## POST EPC MEMORANDUM

RE: PR-2018-001560, SI-2022-02414-Hoffmantown, Site Plan – EPC

Re: Response to Conditions of Approval – SI-2022-2414, Site Plan – EPC

TYPICAL LOT LAYOUT

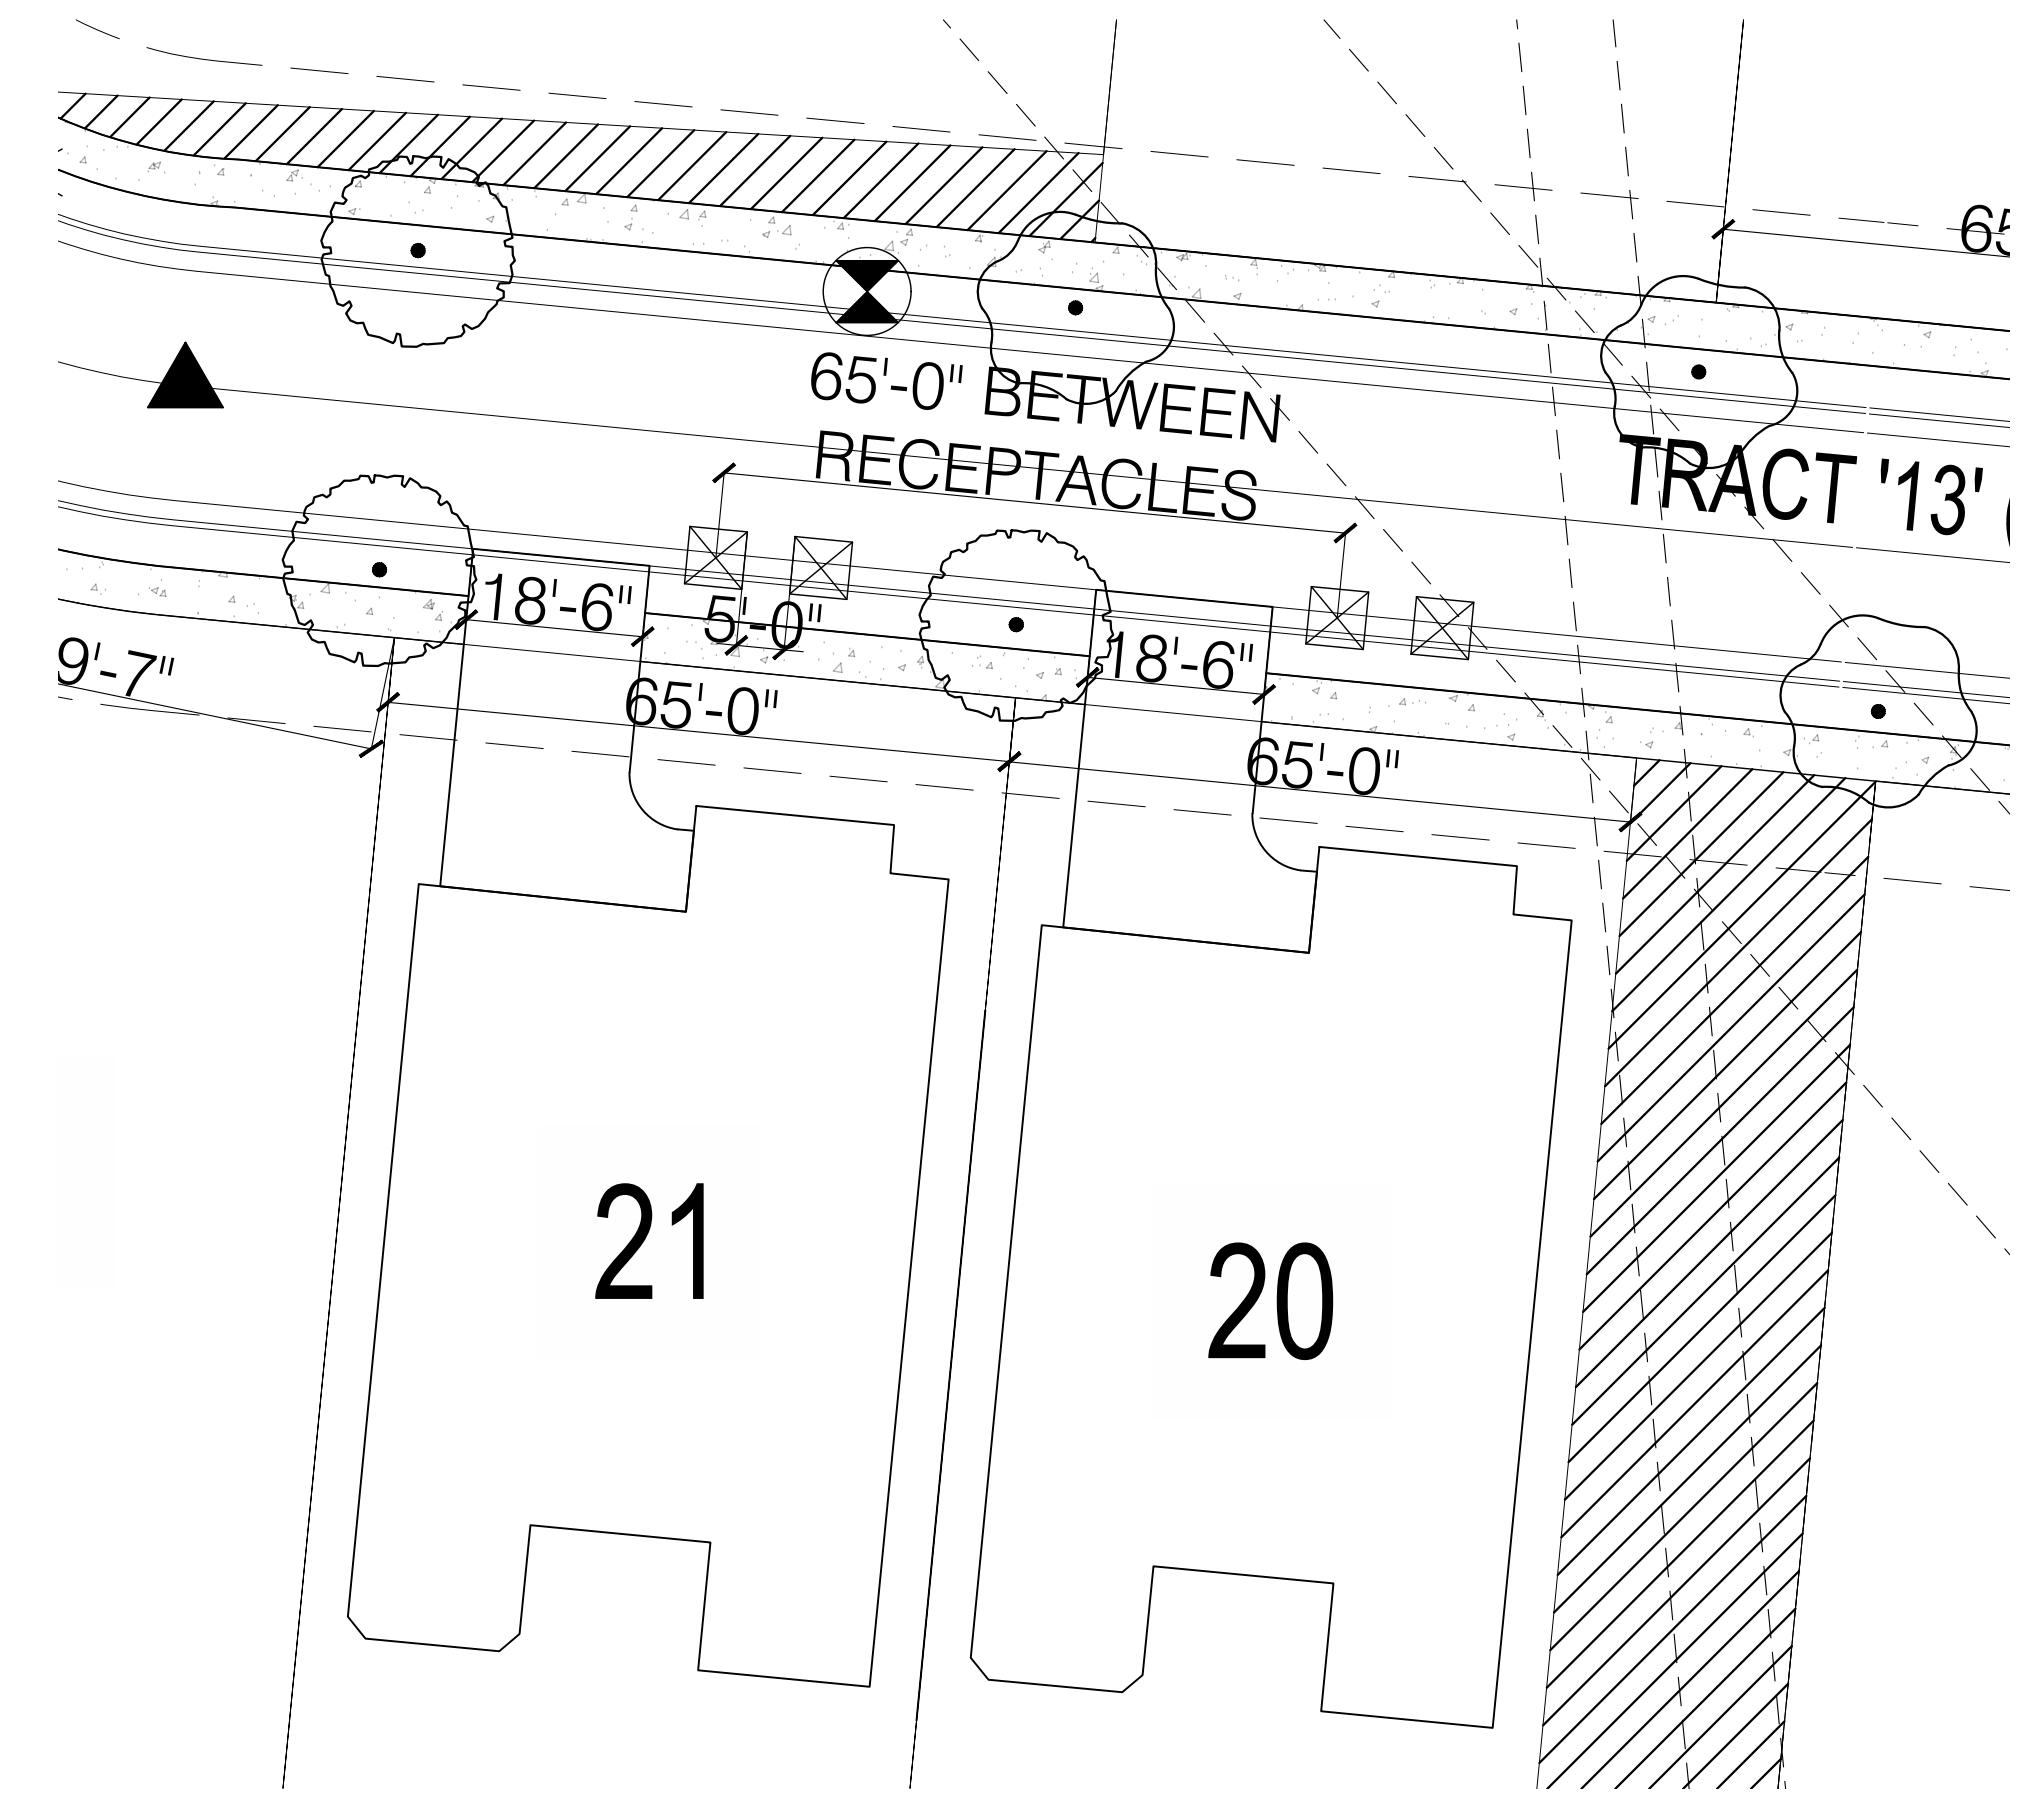
The Solid Waste Management Department (SWMD) will require a site plan that shows the dimensions of the proposed curb space and driveways approved for access by SWMD.

Applicant response: We have worked with Herman Gallegos on responding to this condition and he has signed off on the exhibit showing driveways on the subdivision lots (see exhibit included in Site Plan set).

**ARROYO WALL SECTION**  
NOT TO SCALE

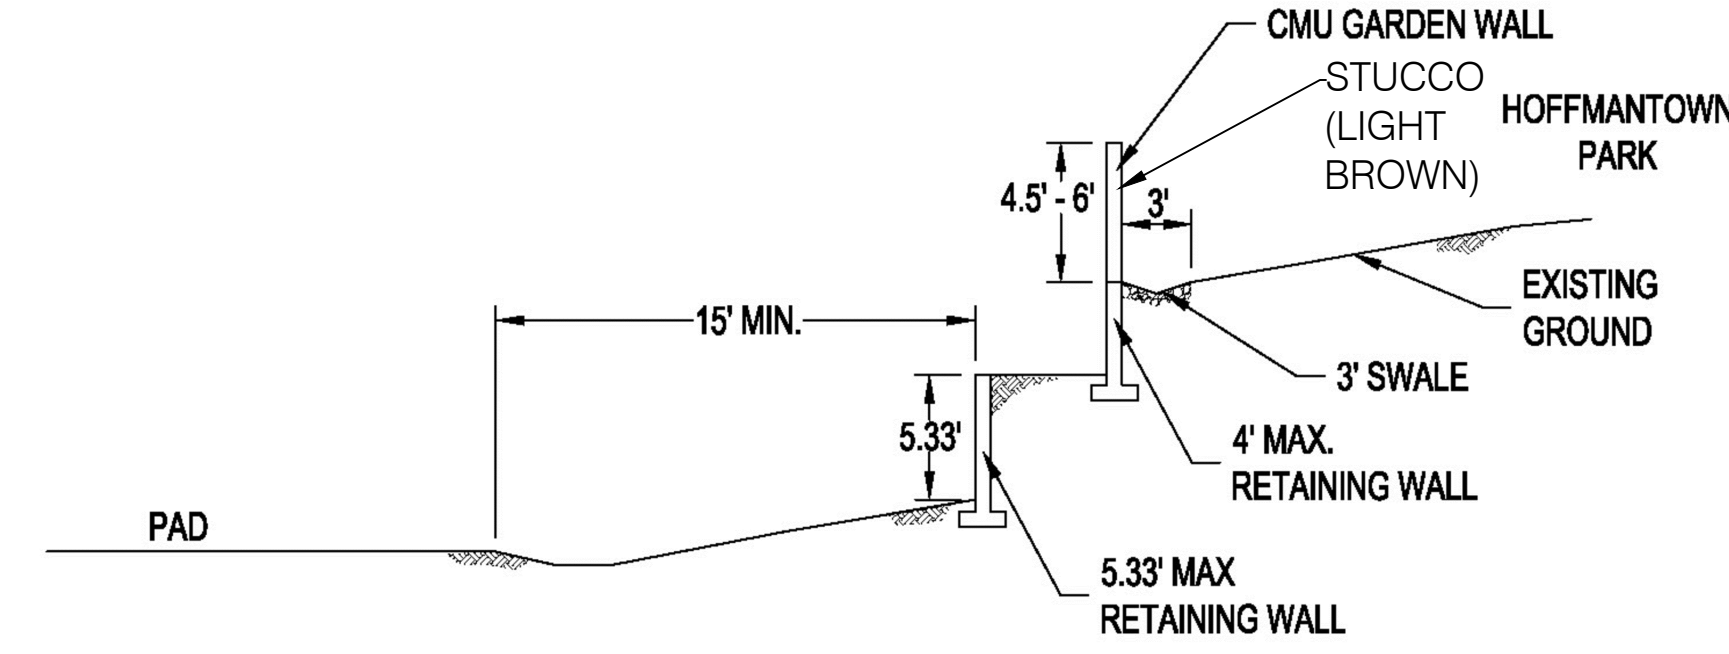
- a. The applicant shall provide an updated retaining wall detail to reflect 5-7(F)(2) standards for Terracing.

- b. The retaining wall detail shall be updated note to state that height is in accordance with 5-7(F) Retaining Wall Standards.

Applicant response: Added on Sheet 2 "Retaining Walls."

Applicant response: Added on "Retaining Walls."

**THE ESTATES AT ACADEMY LANDSCAPE PLAN**

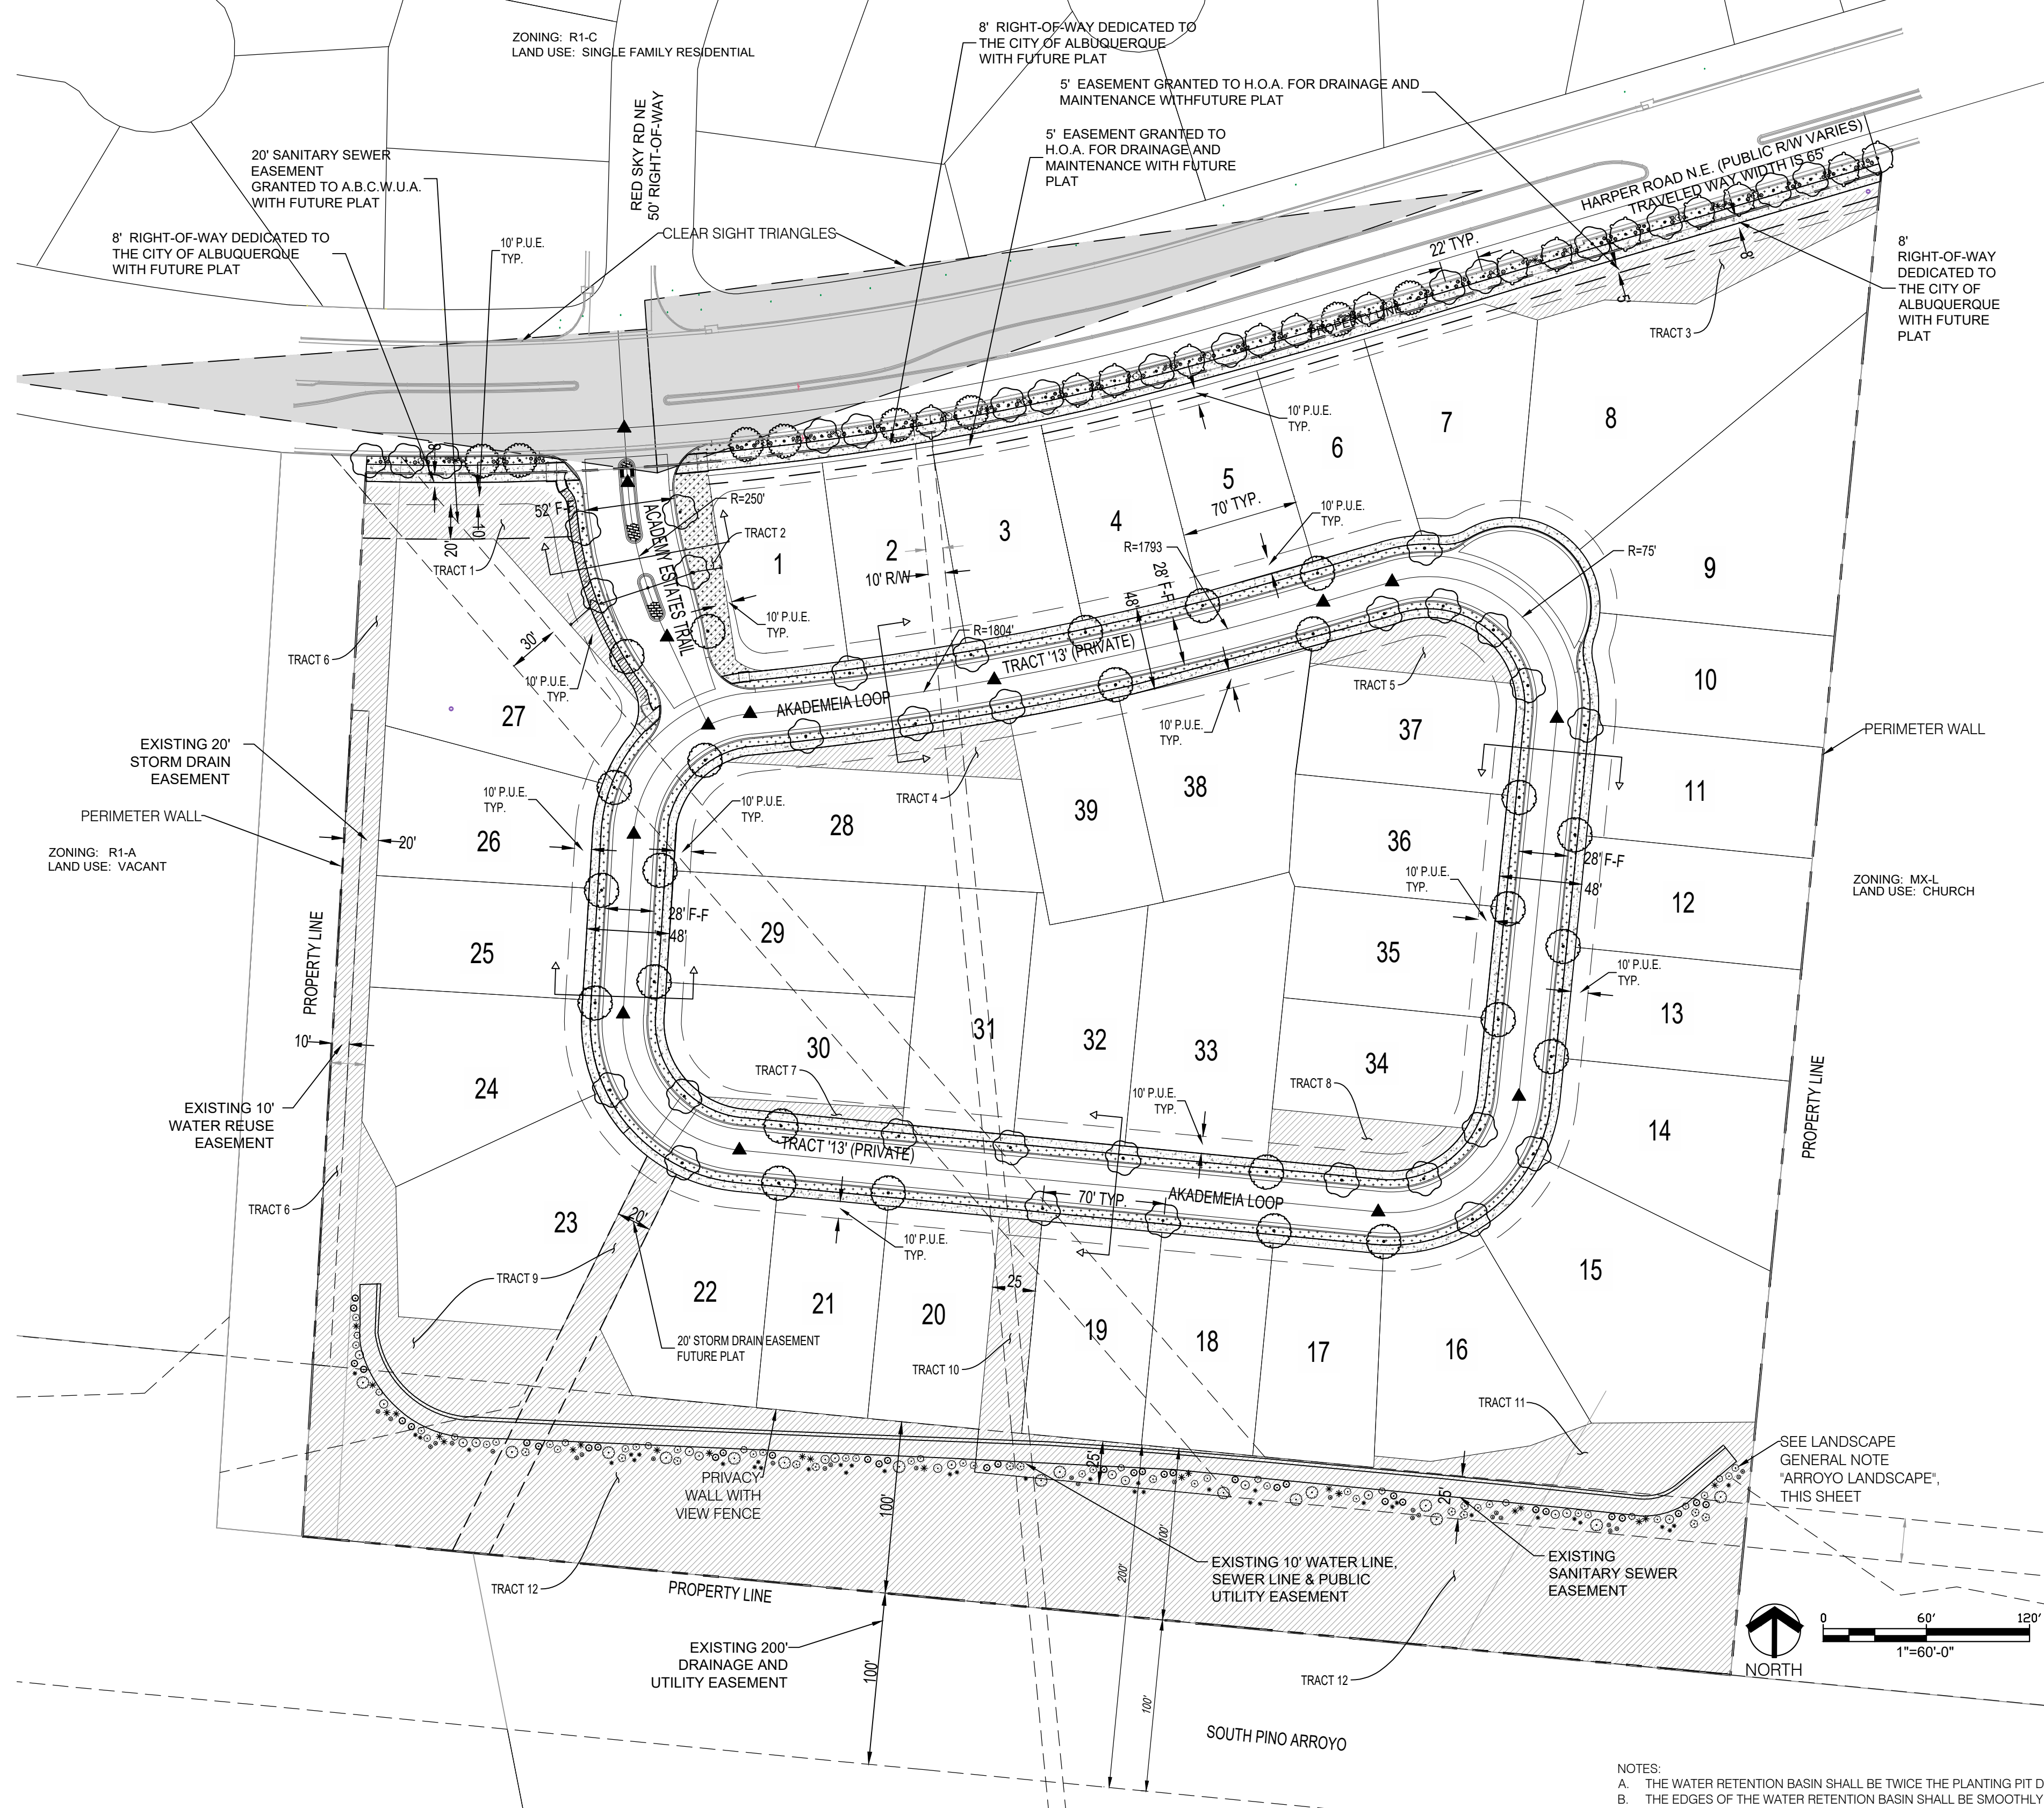
- a. Landscaping adjacent to arroyos shall consist of low-maintenance, native plants included on the Albuquerque Plant palette [IDO 14-16-5-6(C)(4)(e) and in the FPA].

- b. Juniper shall be "female only" (ref: Pollen Ordinance) and chosen from the Albuquerque Plant Palette.

- b. Any on-site transformers shall have a five-foot clear area on the sides and rear and ten-foot in front to allow for access and maintenance.

Applicant response: Plant materials added along the arroyo and note added under General Landscape Notes, Arroyo Landscape, see Landscape Plan.

Applicant response: Juniper has been removed from the Landscape Plan.

Applicant response: Agreed. A note has been added to Sheet 3, Landscape Plan, stating the coordination with PNM regarding tree location and height, sign location and height, and lighting height to ensure sufficient safety clearances.
